PLANNING BOARD REPORT PORTLAND, MAINE

Seaport Lofts (Bay House Phase II)
101-121 Newbury Street and 40 Hancock Street
Level III Site Plan and Subdivision Review
2013-179
113 Newbury Street, LLC, Applicant

Submitted to: Portland Planning Board Public Hearing Date: September 24, 2013 Planning Board Report Number: #42-13	Prepared by: Nell Donaldson, Planner Date: September 20, 2013 CBLs: 20-D-13, 14, 15, 32
--	---

[REVISED 10-15-13]  
[WALL BRACKET]

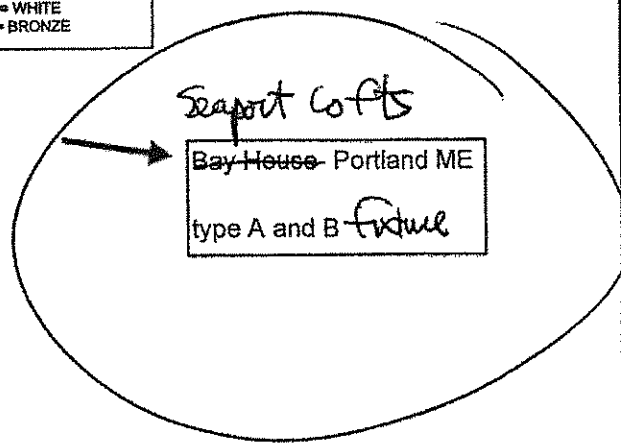
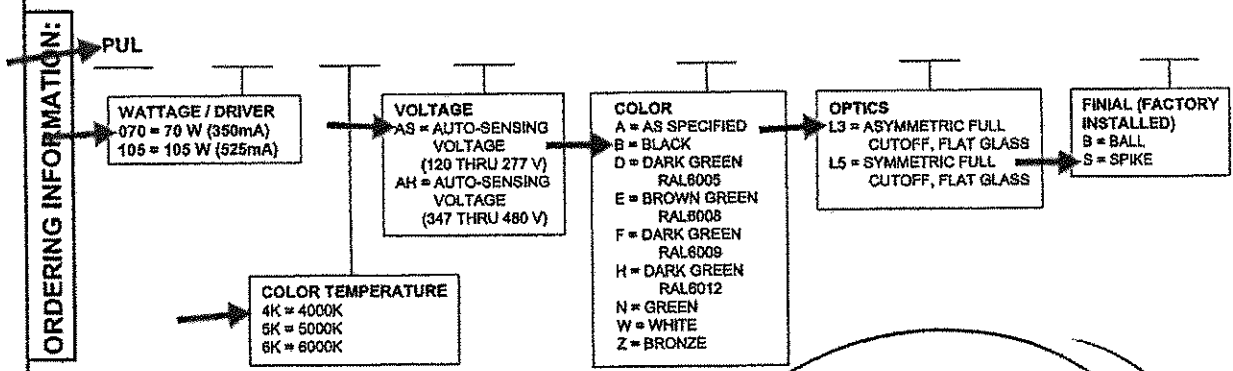
City staff has asked the applicant to reconsider the bracket proposed for the building-mounted lights. Staff has also asked the applicant to reconsider lighting the vestibules at the first floor doorways, which are currently unlit.

Drawing file: 10_3_13_revised submittal / City Submittal 5.5 - Sheet 12 Details.PDF

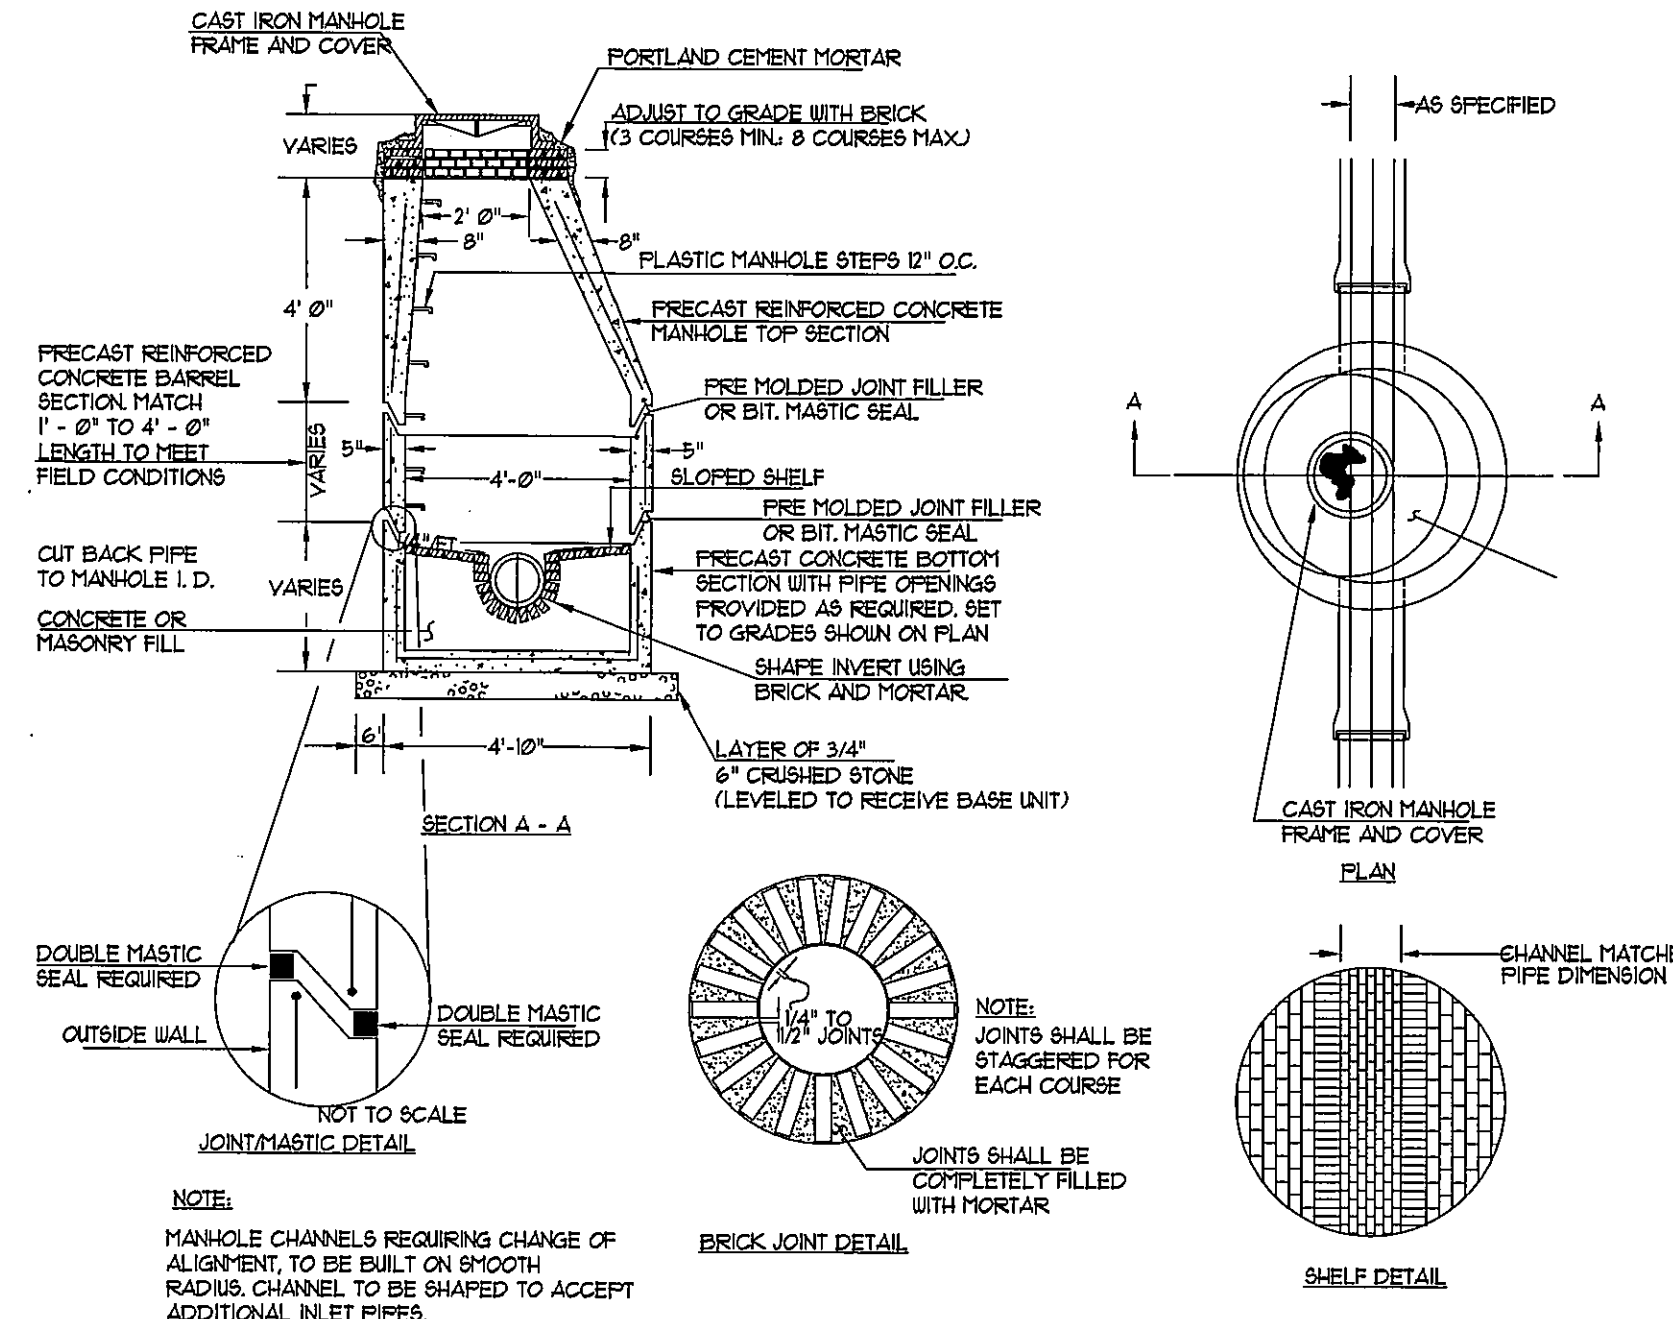
The Grading and Utility Plan (Sheet 6) proposes a "4-inch Tree Pit Underdrain" below the sidewalk along Newbury Street. Upon consultation with City Arborist and DPS staff, unless there is a project-specific design reason for this underdrain, please remove this notation on the plan and the associated detail on Sheet 13.
